A14 Cambridge to Huntingdon Improvement Scheme Team
The Planning Inspectorate
National Infrastructure Directorate
Temple Quay House
Temple Quay
Bristol
BS1 6PN

A14 Cambridge to Huntingdon Improvement Scheme

Environment Agency Written Representations

Respondent Reference No. TR010018

Drawing number: **A14-ARP-ZZ-00-DR-Z-00109** Rev: **0**

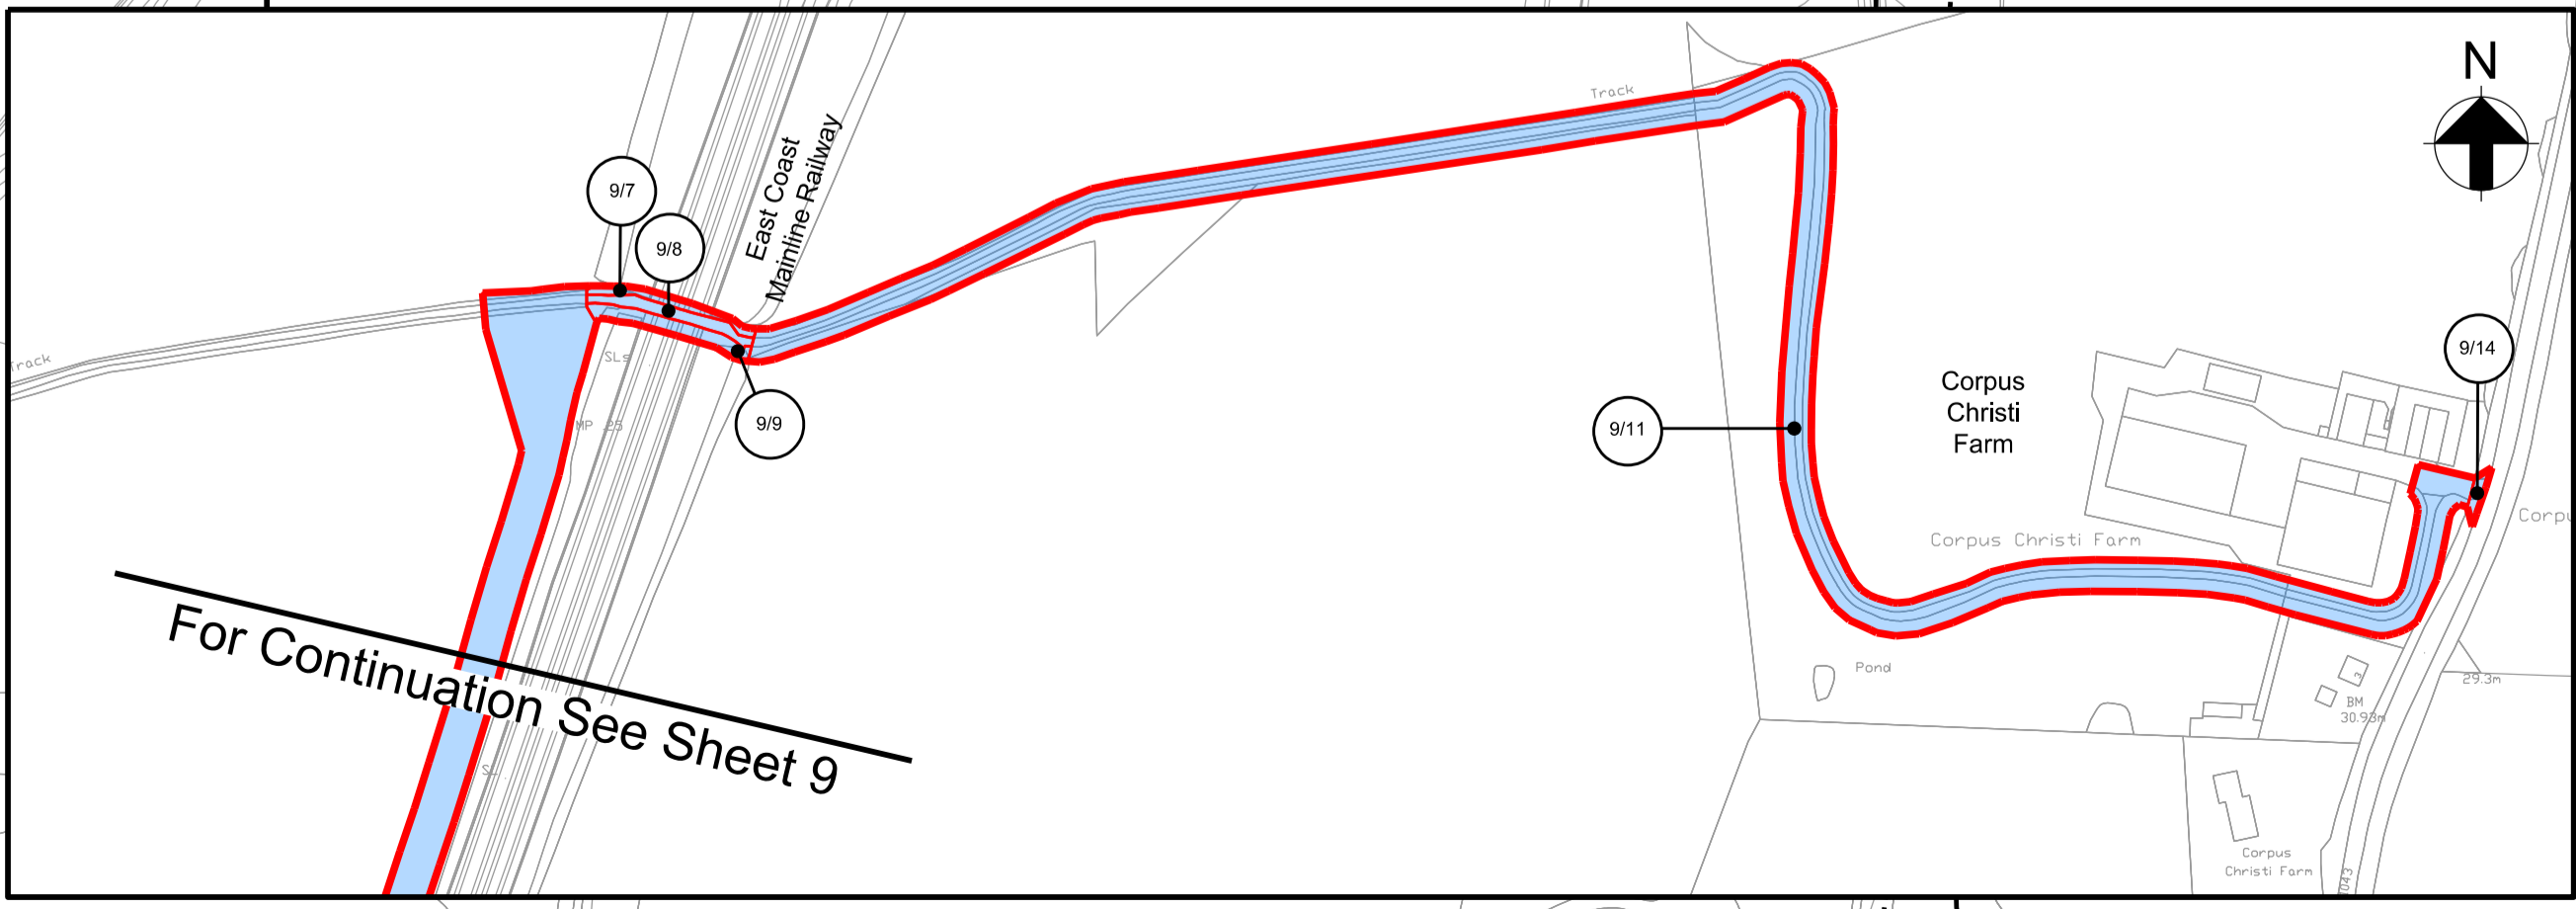
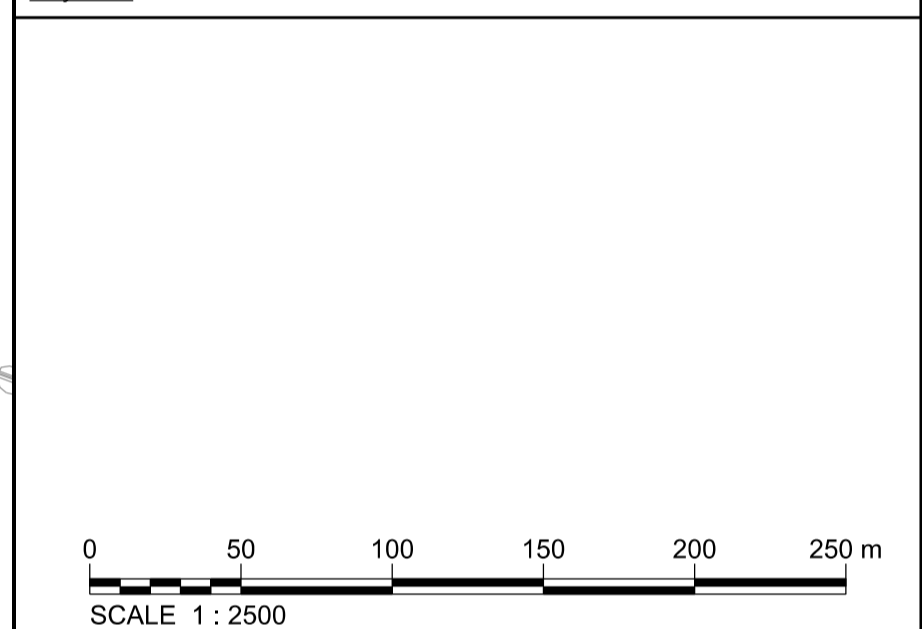
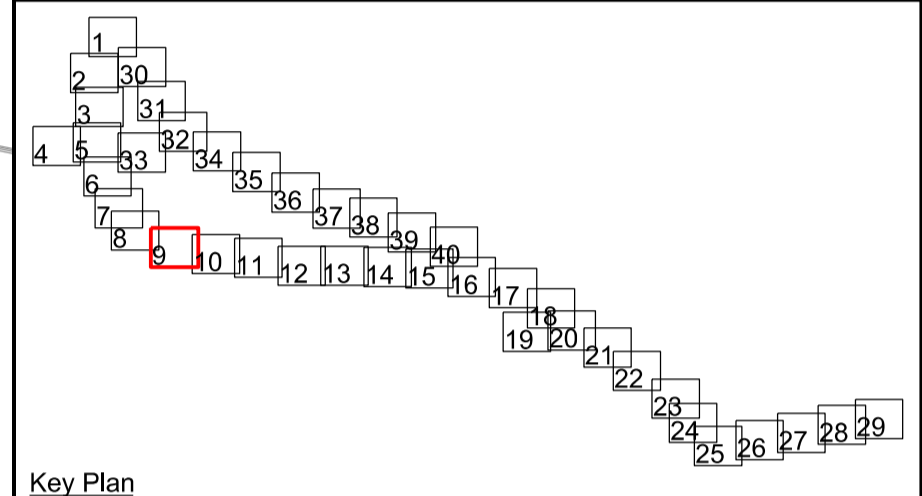
1.10.1 Issues 1.10 to 1.12 relate to the increase in flood levels at three locations, as indicated in the Flood Risk Assessment in the ES. In all three locations, the applicant needs to seek agreement with the relevant landowner regarding the change in flood risk to their land. Information relating to the engineering works and flooding implications needs to be provided to landowners and responses to this consultation should be used to inform the decision making process. We have been advised that the applicant is in discussion with the affected landowners and will seek their formal agreement to the change in flood risk.

1.12 – River Great Ouse - The affected land is located on Land Plans Regulation (5) (2) Sheet 9 of 40 (Reference A14-ARP-ZZ-00-DR-Z-00109). This plan shows land that could be affected as outside of the acquisition area.
